Recommendation Report for Planning Permission for Works or Extension to a Dwelling

REF NO: FG/156/21/HH

LOCATION: 24 Oval Way
Ferring
BN12 5RA

PROPOSAL: Erection of first floor side extension, garage conversion and the addition of a front porch.

A :: **Proposed First Floor Plan**
03 scale: 1:100

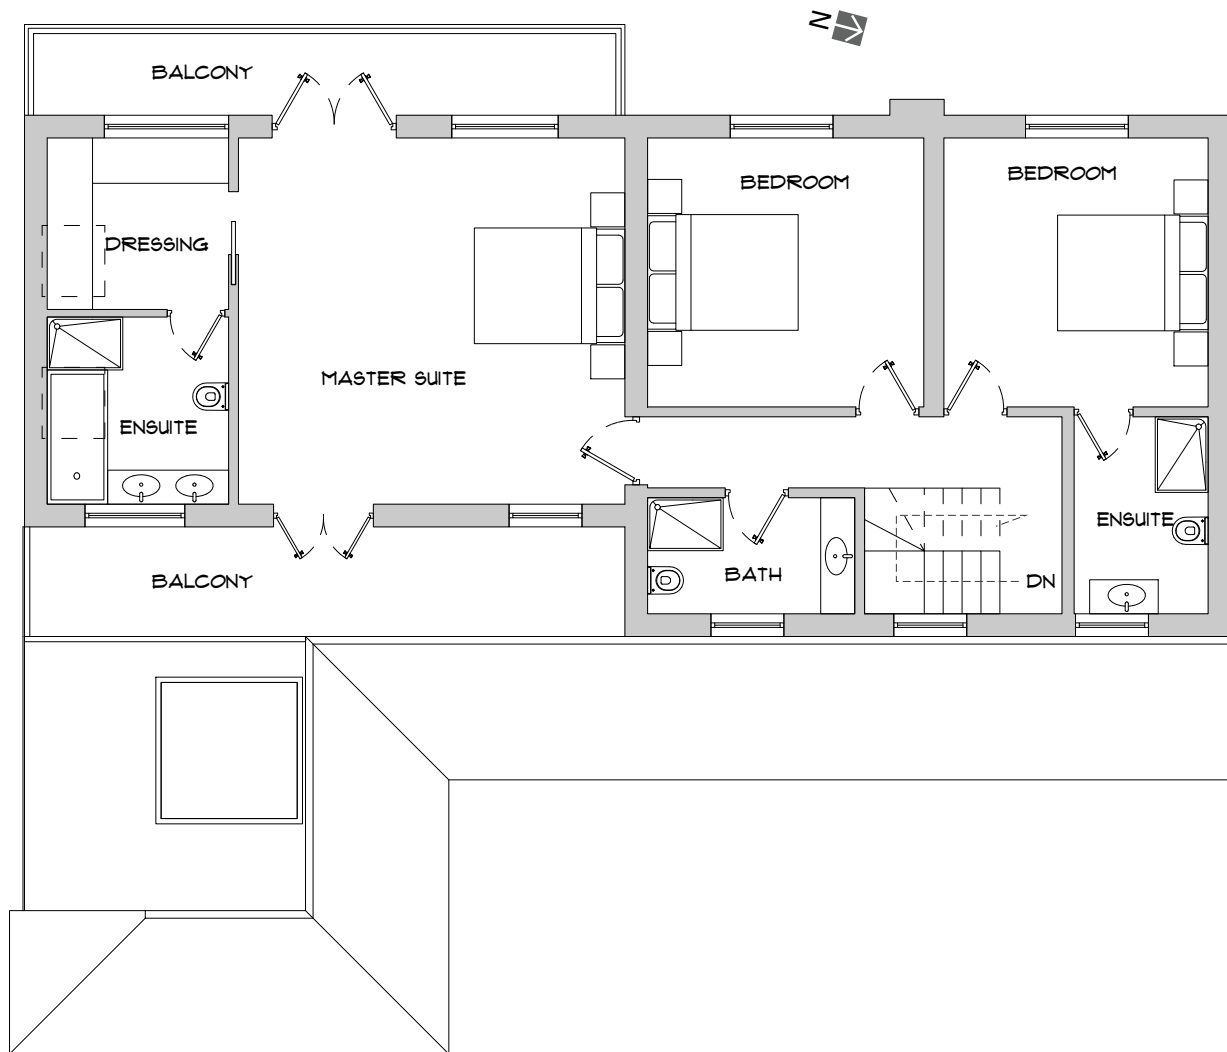
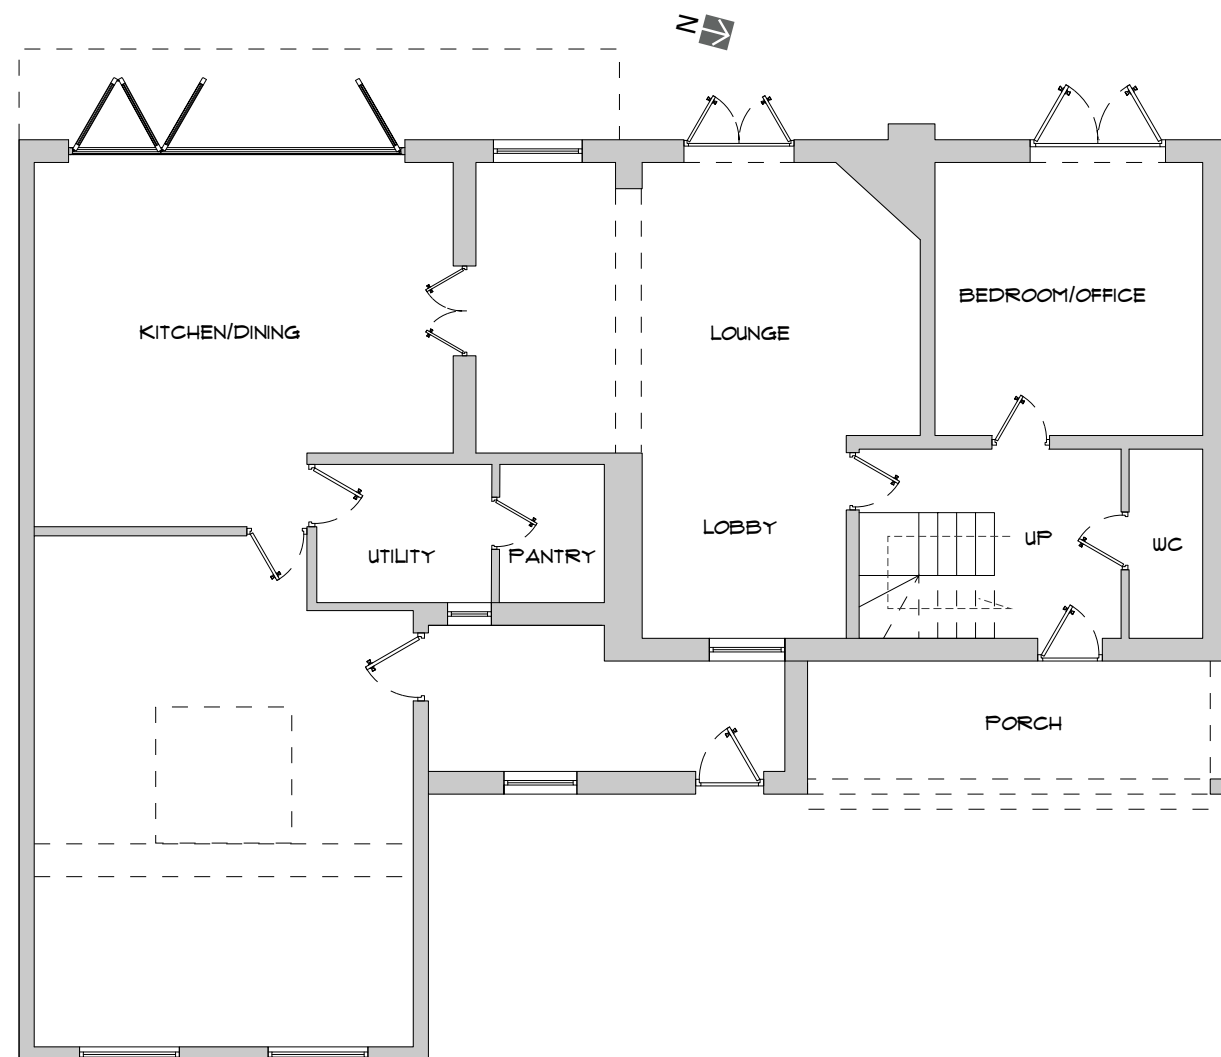
The proposed development seeks to perform various extensions and alterations to the host dwelling. This includes a first floor extension of a significant scale however, it must be noted that this application compared to that of FG/7/21/HH, is for lesser works, including the scaling back of these first floor extensions. The proposal is to provide a first floor extension to the south, partly above the existing garage and kitchen. The extension will be set back from the primary elevation and its narrower width has lead to a lower ridge height than the host dwelling. The existing garage will be re roofed with a slightly higher pitch parapet roof, continuing along over a new front porch. The new roof although marginally higher, provides a more visually attractive elevation. Because of the reduction in scale and intensity of the scheme, and because of the reduction in scaling when compared to the dwelling the proposed extensions is considered subservient to the host dwelling.

A :: Proposed West Elevation
04 scale: 1:100

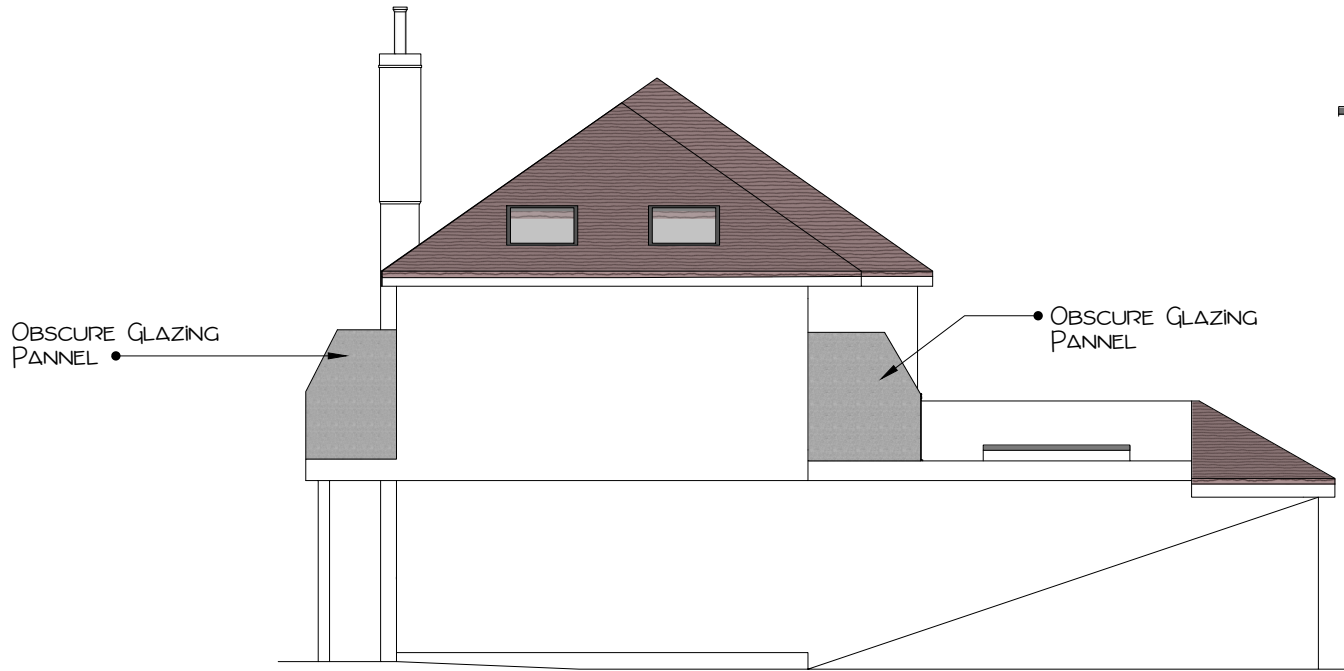
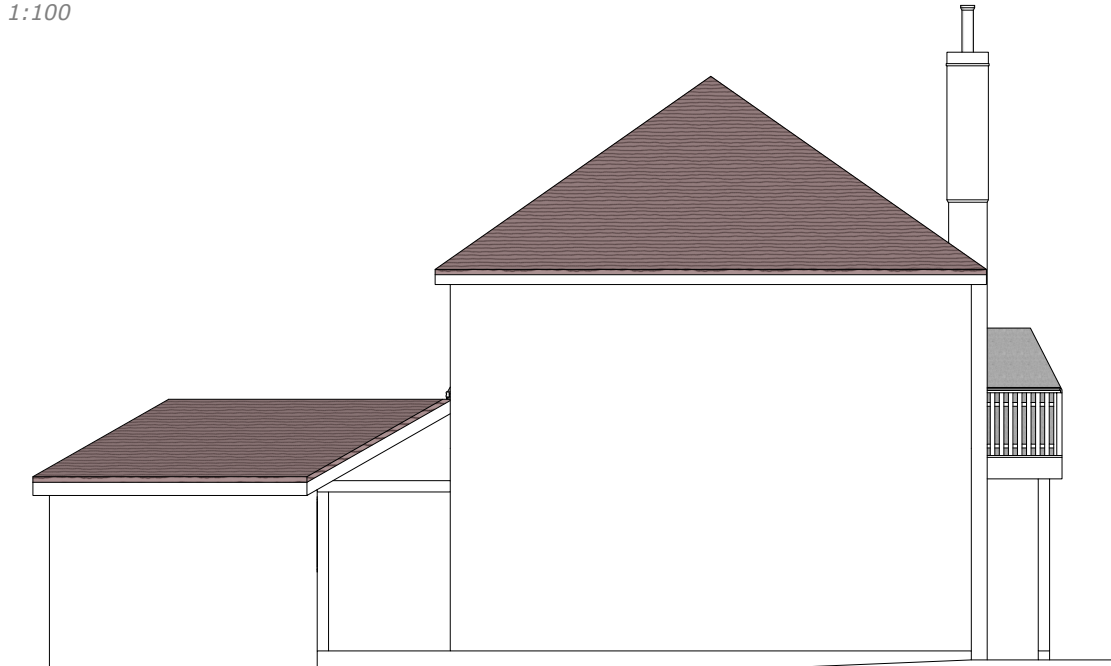
The proposed development is not considered to result in any harmful loss of privacy to the occupiers of neighbouring dwellings. This is because the proposed balconies provide screening to prevent any direct overlooking to the South. The other views available from the proposed development are not considered to result in any significant harm to local occupiers, in that they are similar to those from the host dwelling at current.

- 3 The obscure glazing panels on the Western elevations of the balconies shall be retained to a height of 1.7m in perpetuity.
